Planning Application 19/02796/FULL OS Parcels 3309 & 4319 adjoining LNMR

Further to our previous letter of objection earlier this year please find below our additional response to the latest published amendments which include the site layout, car park lighting, roller shutters to the pavilion, MUGA fencing, ball stop fencing and additional tree and hedge planting.

1 North Elevation
1 : 100

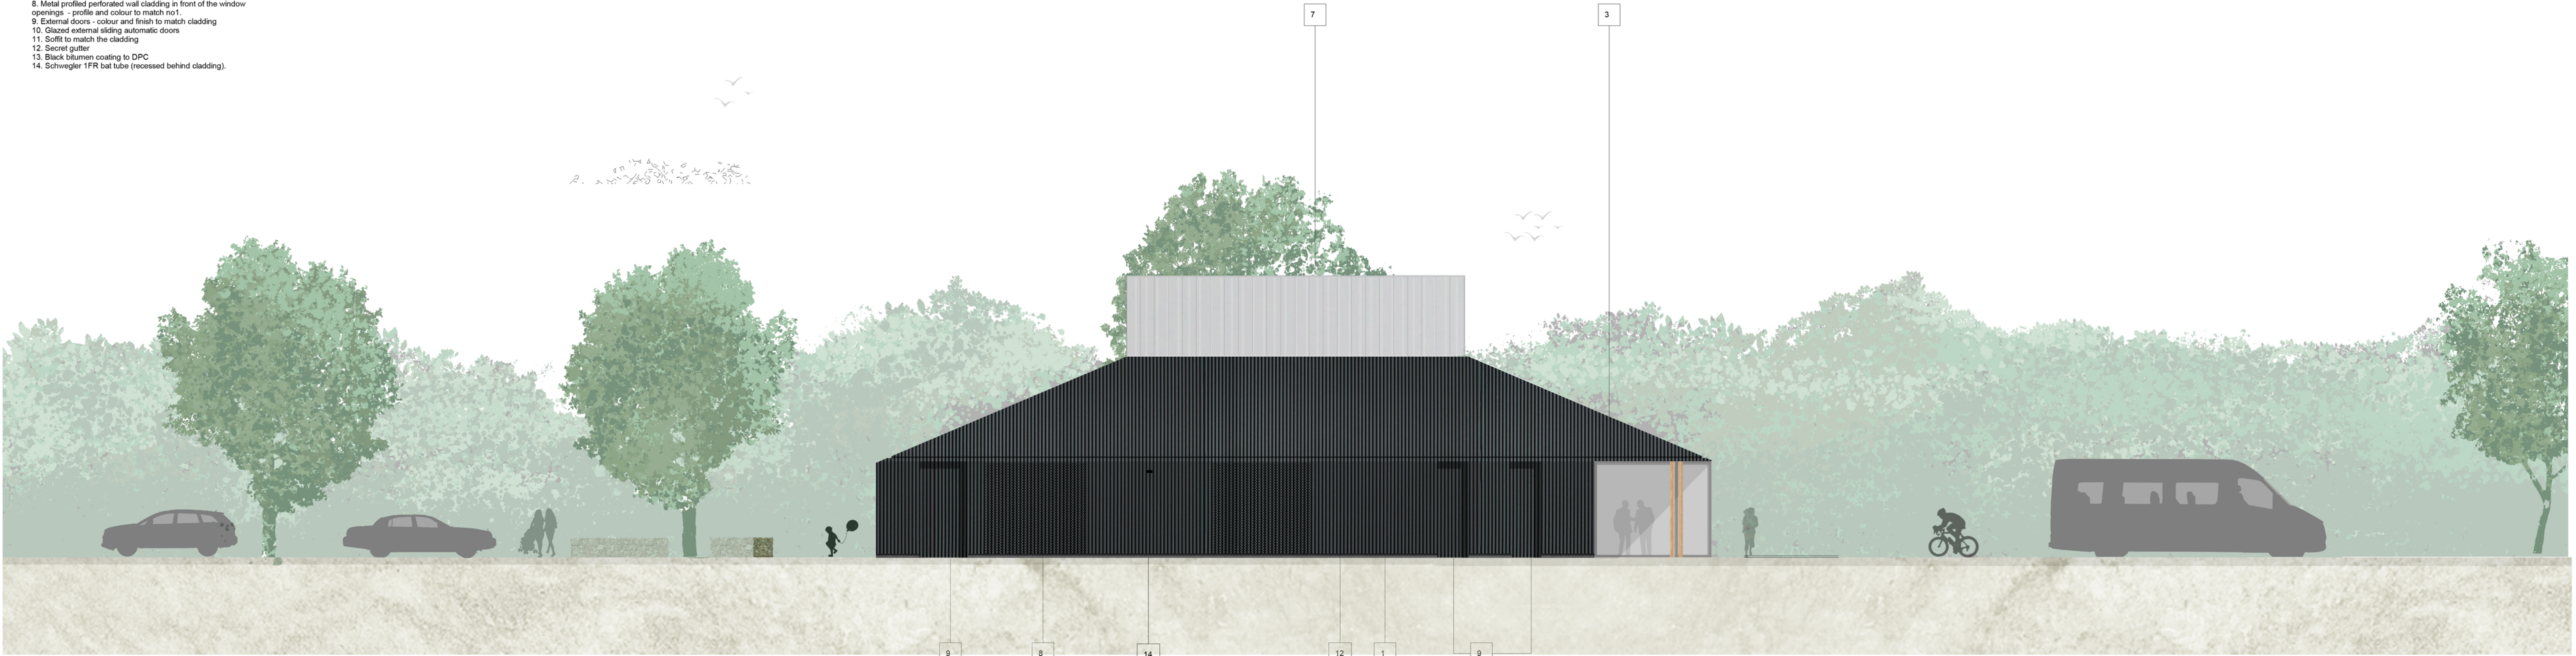
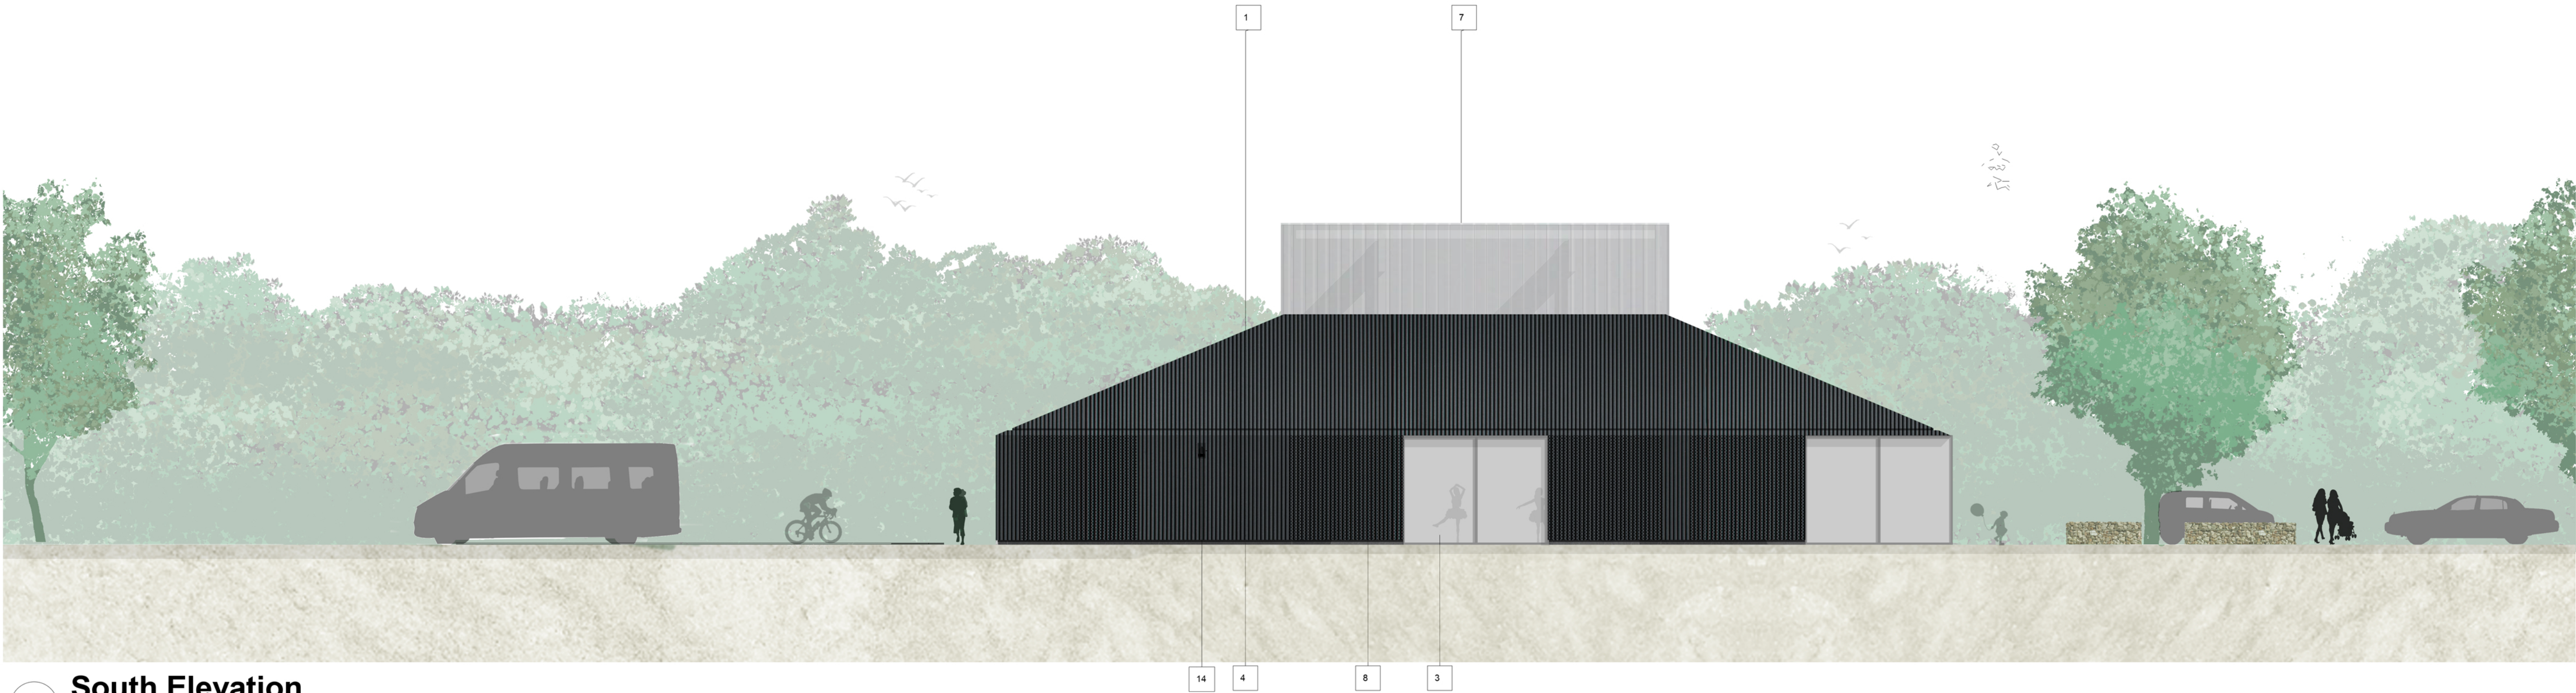
- We consider the proposed external facings of the pavilion and its construction materials ugly and inappropriate. Dark metal shutters are more suggestive of a penal facility than a vibrant community centre. The designers' claim that the dark colour will recede into the landscape like a rural barn are hard to reconcile with their assertion that it will also make a bold statement.
